10 September 2019

**UNIVERSITY OF NEWCASTLE HONEYSUCKLE CITY CAMPUS CONCEPT PLAN  
(SSD-9262)**

I refer to the Department's email of 2 August 2019 advising the University of Newcastle has submitted a Response to Submissions (RtS) for the above application which was placed on public exhibition from 15 to 28 August 2019 and inviting City of Newcastle ('CN') to comment.

Figure 6 Overshadowing of amended building envelopes

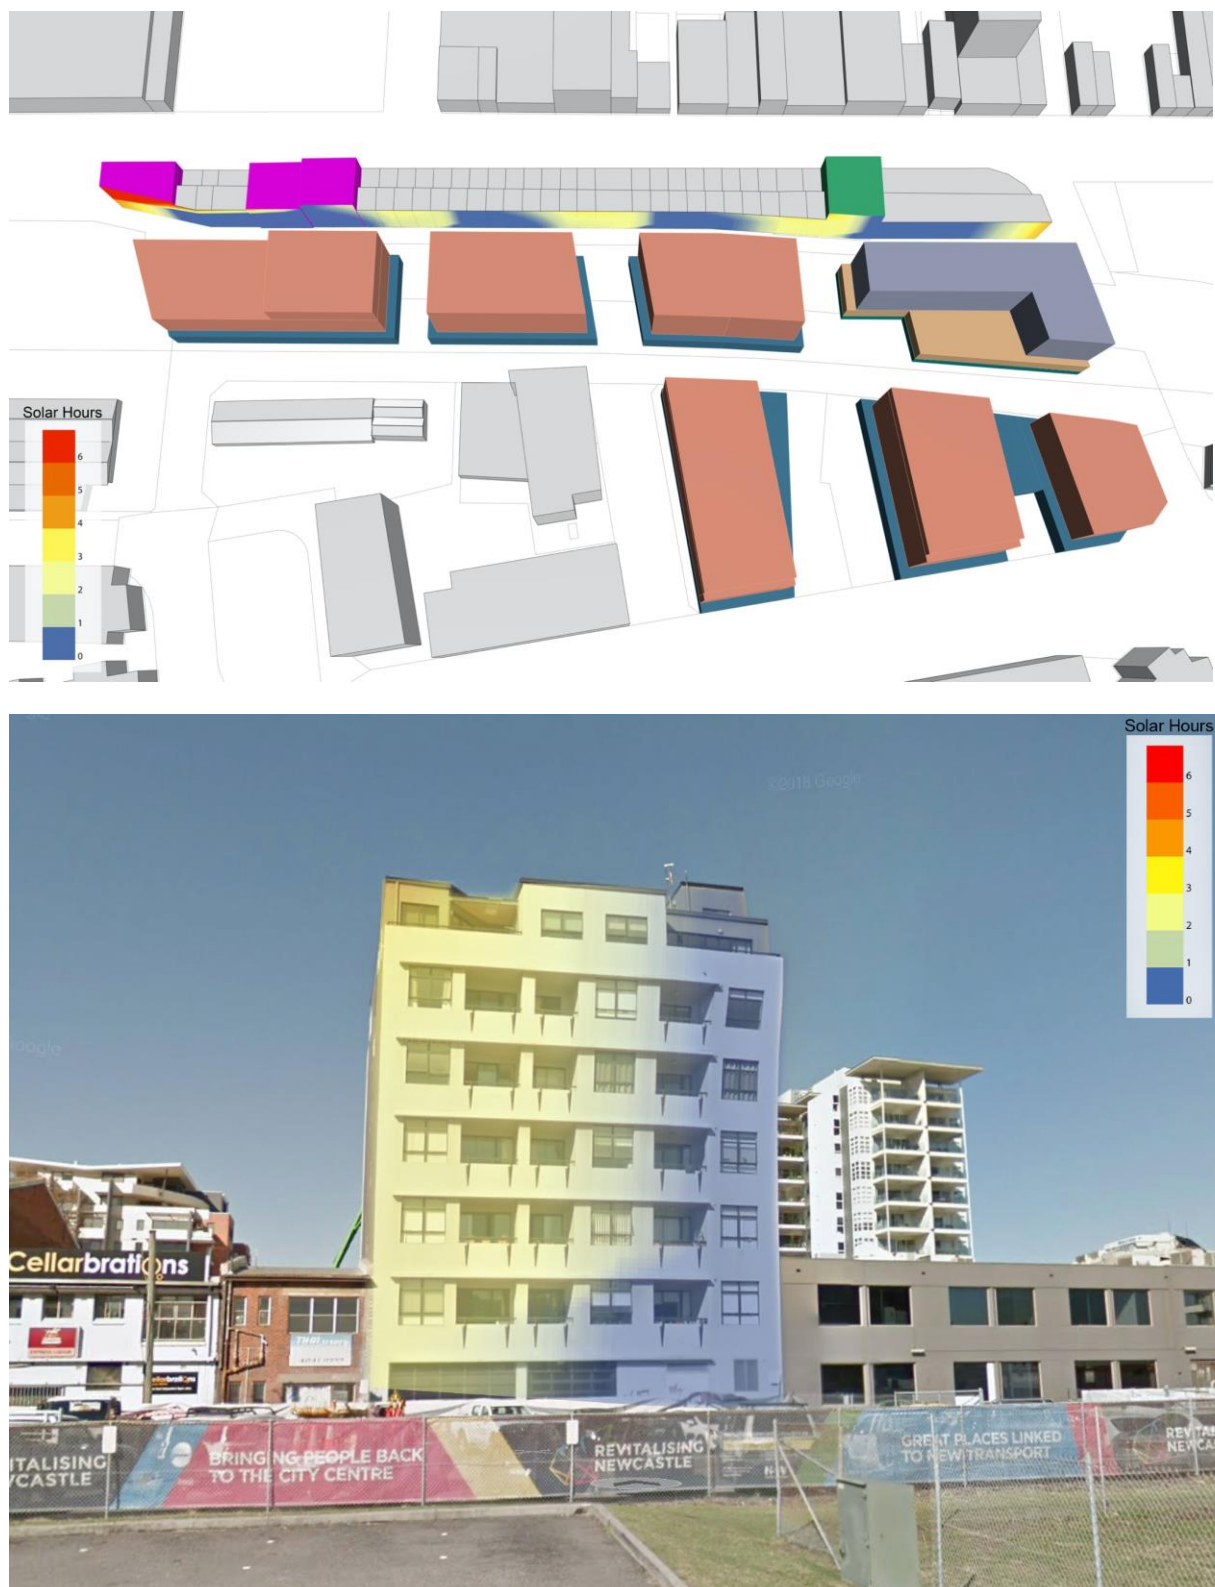
In considering the likely overshadowing impacts on the existing development on 522-526 Hunter Street (26 dwellings) and the other 'residential' properties on the southern side of Civic Lane the RtS states:

*'With the exception of the uppermost level, the western side of the northern façade (of 522-526 Hunter Street) would receive no direct solar access if the envelope were to be completed filled. However, it is noted that this would not occur as articulation of the built form will be required through the detailed design process.'*

*'... the building envelopes represent the maximum built form massing for any part of the site and will be refined as part of the design development process. Subsequent applications for the detailed design of buildings will further consider solar access to surrounding properties and the design of the buildings will seek to minimise overshadowing where possible.'*

While the RtS argues that subsequent development applications for the detailed design of the buildings will further consider the solar access to surrounding properties, it is also conceded that:

*'... a substantial reduction to the height of the development at the University campus would be required to allow solar access to reach the lower levels of a potential residential development along Civic Lane.'*

While the likely positive contribution of the development to the revitalisation of the City Centre is recognised, the development should not unreasonably impact on the existing developments or the future development potential of the properties on the opposite side of Civic Lane. As such, consideration should be given to ensuring that these likely impacts have been satisfactorily addressed by the Concept Plan.
